A1 in Northumberland  
National Infrastructure Planning  
The Planning Inspectorate  
Temple Quay House  
Bristol  
BS1 6PN

### **Application by Highways England for an Order Granting Development Consent for the A1 in Northumberland – Morpeth to Ellingham**

**Deadline 10 – 29 June 2021**

Footway connection from overbridge footway to existing footway on de-trunked A1

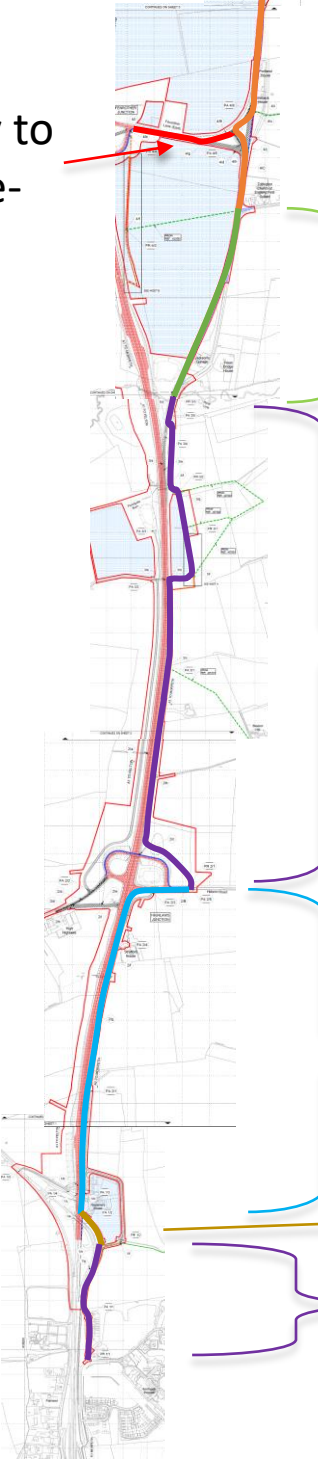
With regard to completing the connections at Highlaws, Fenrother and Causey Park we do not agree with the statement made under Point 9 of the Applicant's Response in respect that these footway connections between the de-trunked A1 and those provided by the scheme are the responsibility of NCC. The gaps in the NMU network at Fenrother and Causey Park are solely due to the delivery of the scheme and not because NCC have "failed to elect to" provide footway connectivity. The scheme introduces new footways at the Fenrother junction and Causey Park bridge, which is deemed required by the Applicant, yet does not make the connectivity to the existing provision of footways on the de-trunked A1. We fail to understand how the Scheme is not required to close a gap in provision of its making through the provision of footways at the grade separation at Fenrother and Causey Park to connect with the existing provision on the de-trunked A1.
